Application No: P/86/22/HH
Site Address: Rose Cottage Priors Way Pagham PO21 3JU
Description of works: Single storey front extension, following demolition of existing swimming pool.

Thank you for your internet representation made on 24th June 2022 which has been recorded as an objection with the comments as follows:

PROPOSED GROUND FLOOR PLAN

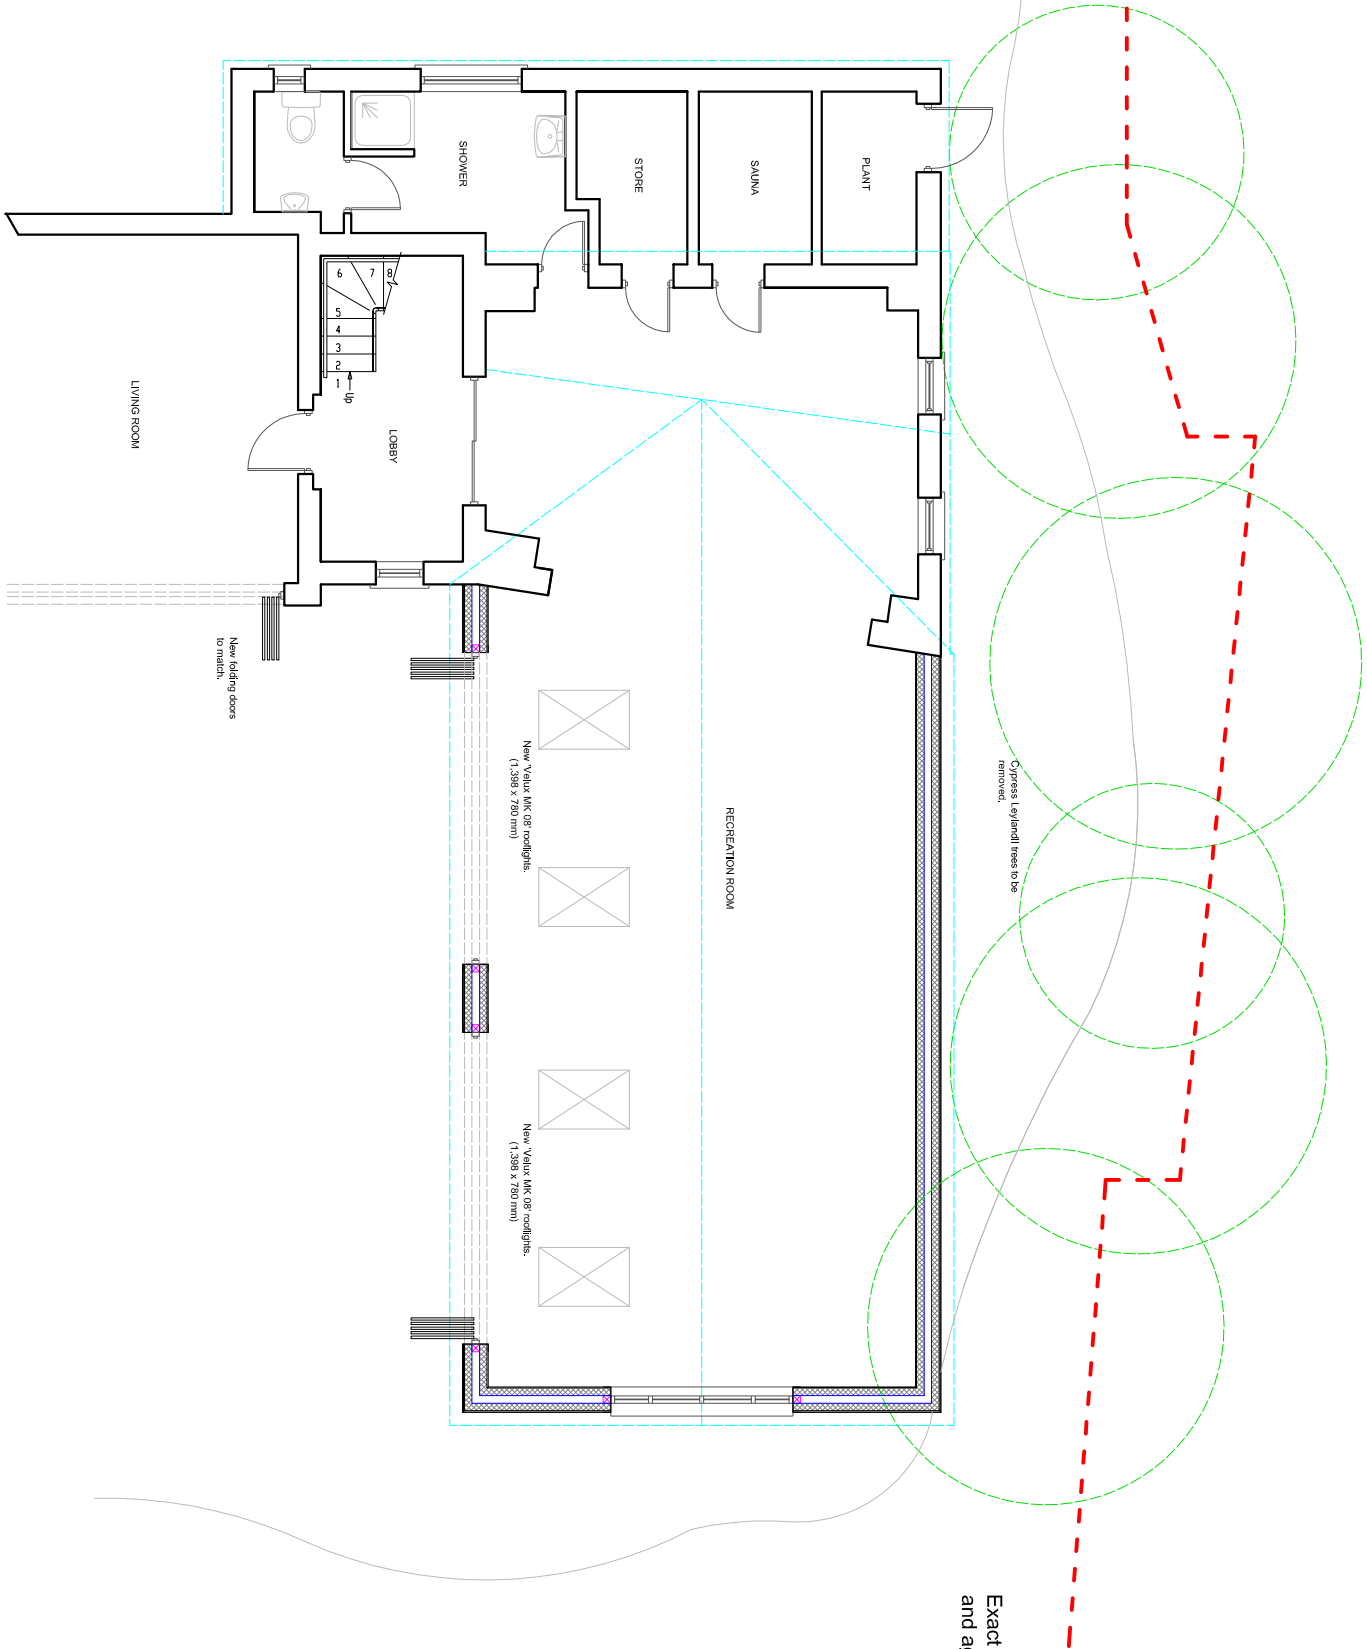
Will there be unreasonable noise arising from the Plant Room shown on the plans? What distance will exist between the rear of the extension and the boundary fences? The plan show one measurement of 1.75m which seems to taper, but the plans also state the distance is to be established at time of build and whilst on site. What is the planned ridge height for the extension?
